CITY OF ALBUQUERQUE
MUNICIPAL DEVELOPMENT DEPARTMENT
ENGINEERING DIVISION

SUBJECT: Tract X East End Addition - Heights Club
Inc.

SUBJECT: HEIGHTS CLUB - DRAINAGE AND GRADING PLAN

REF: DRAINAGE PLAN FOR HEIGHTS CLUB (J19-D31) RECEIVED MARCH 26, 1985

## HEIGHTS CLUB DRAINAGE PLAN

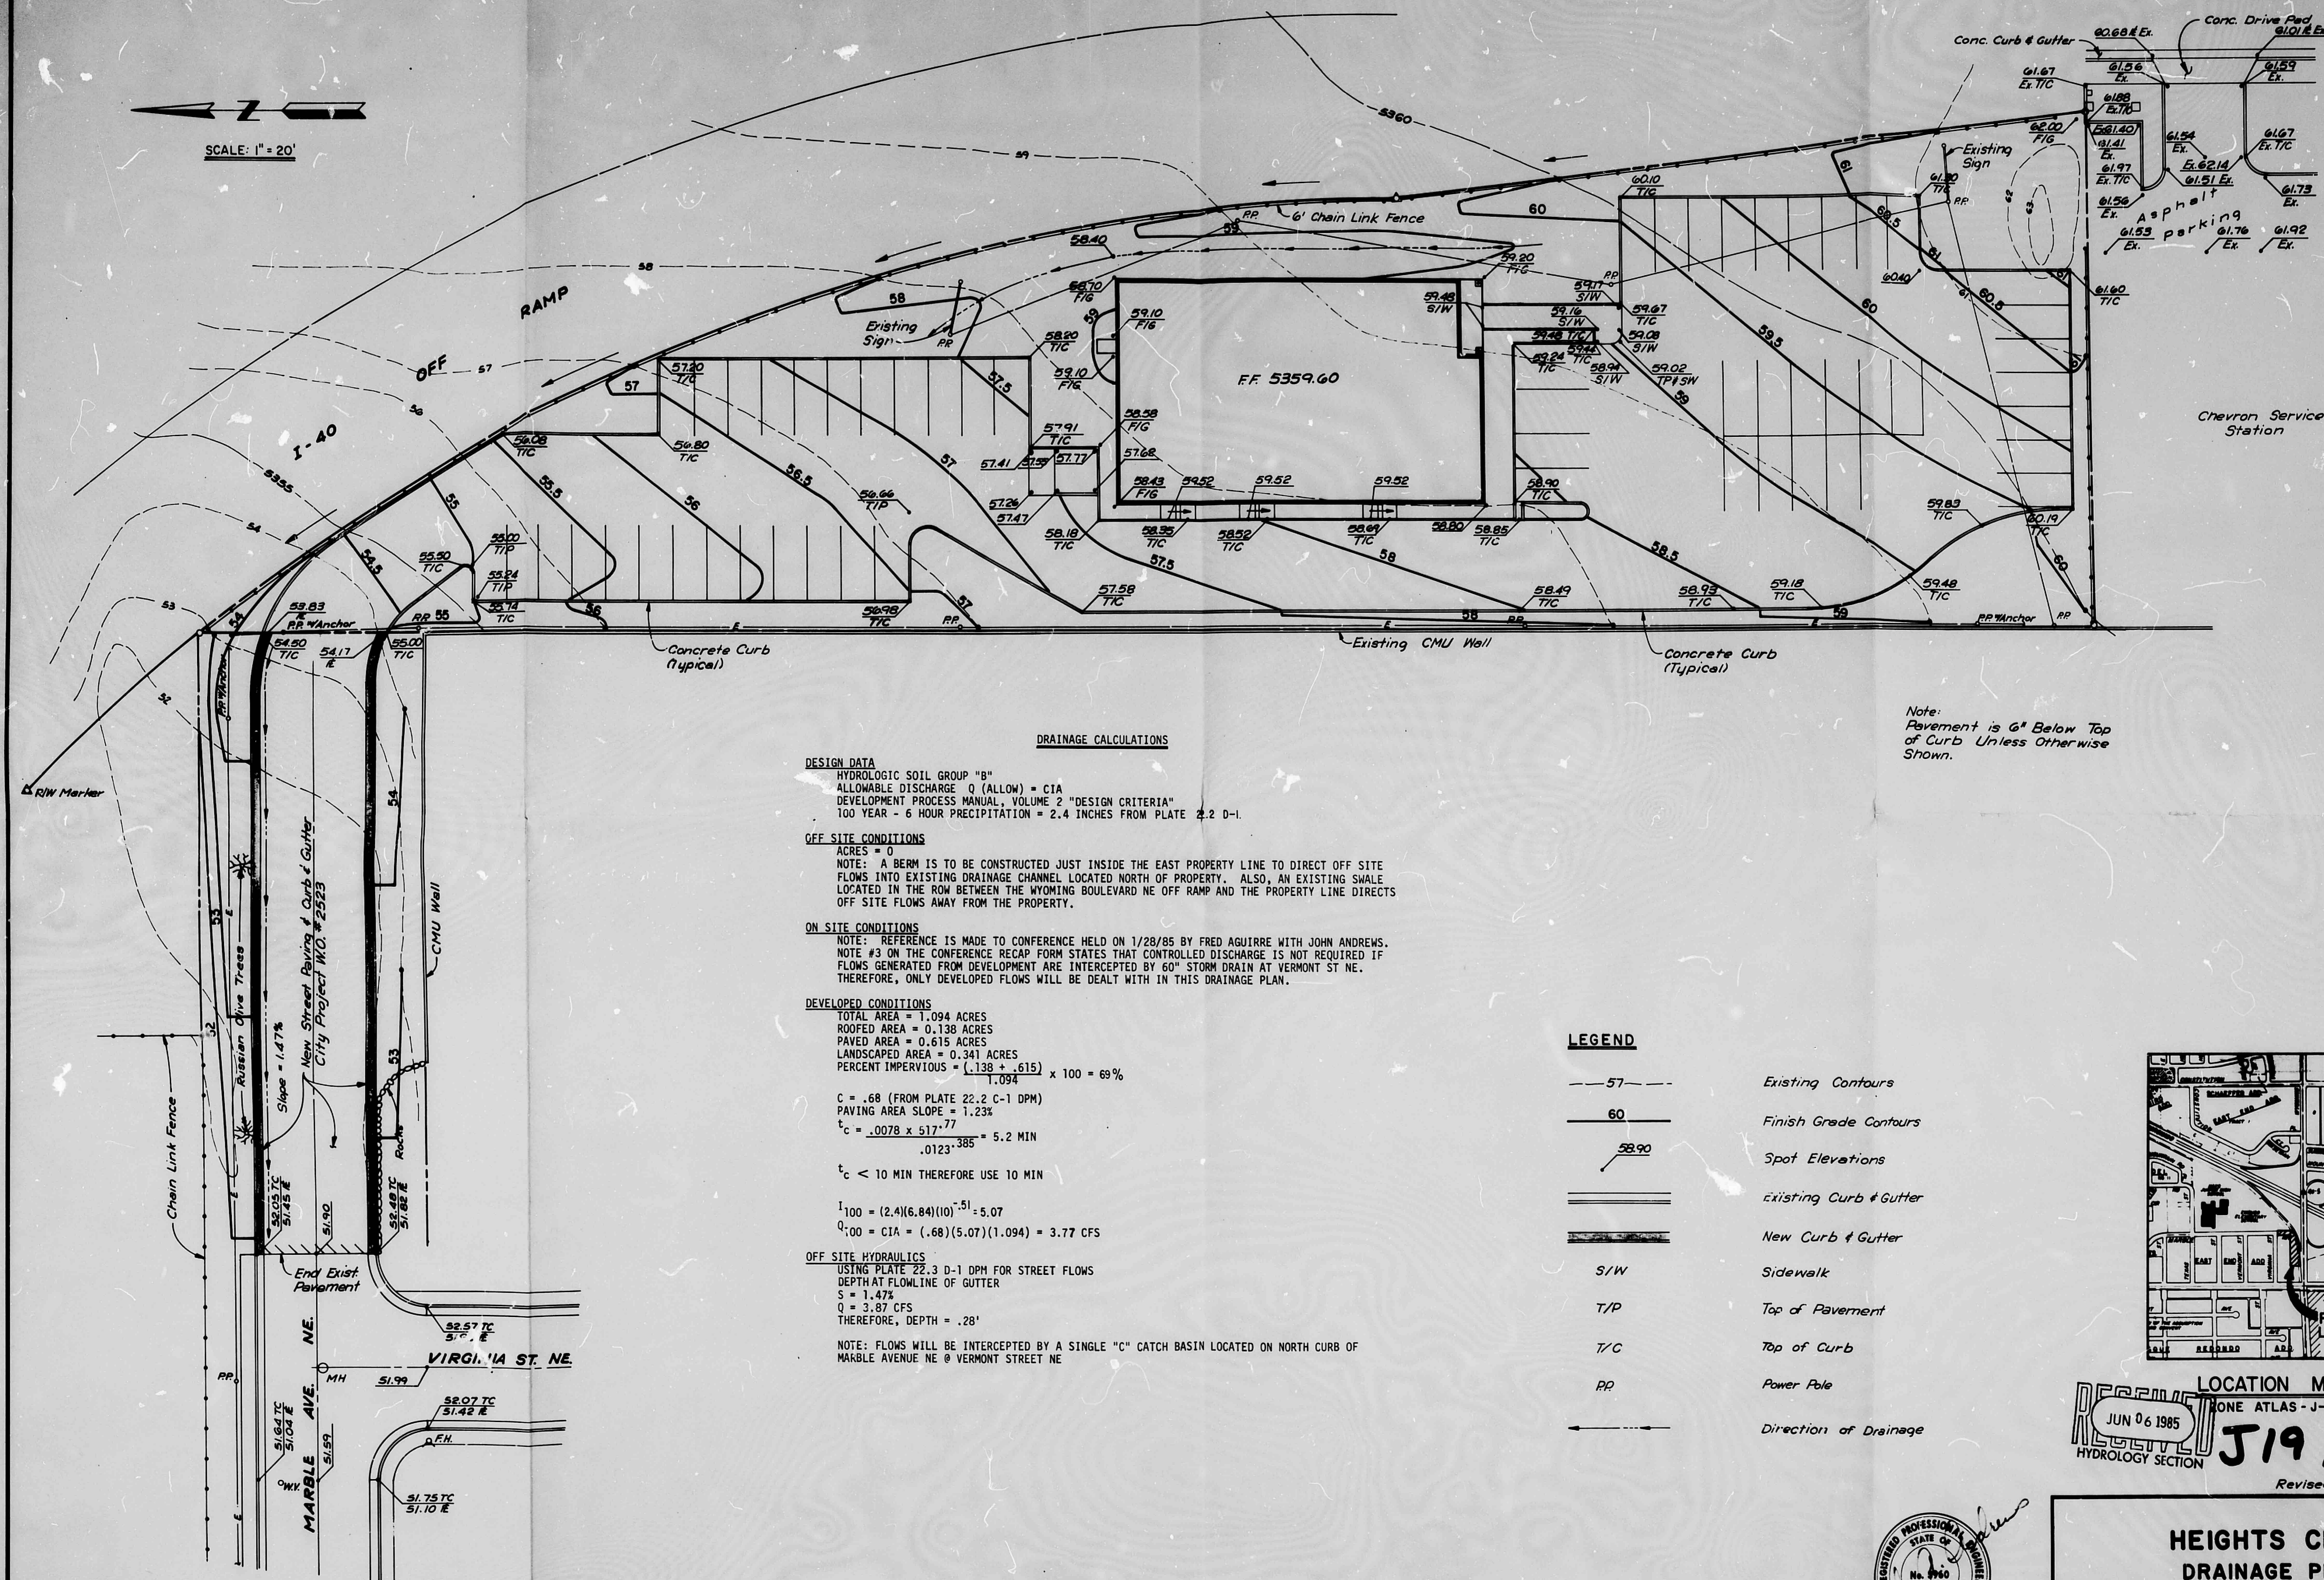
1. Please indicate the work order project number for the new street.
2. Subdivision Improvement Agreements will be required for the infrastructures prior to Building Permit release.

Attached is the grading and drainage plan for the Heights Club which has been revised as per the comments in your letter dated May 28, 1985.

The June 5, 1985, submittal completes my first comment from my May 28, 1985 letter. The Subdivision Improvements Agreement is required for building permit release. Also, for rough grading and foundation only, an erosion control plan is required and a top soil disturbance permit.
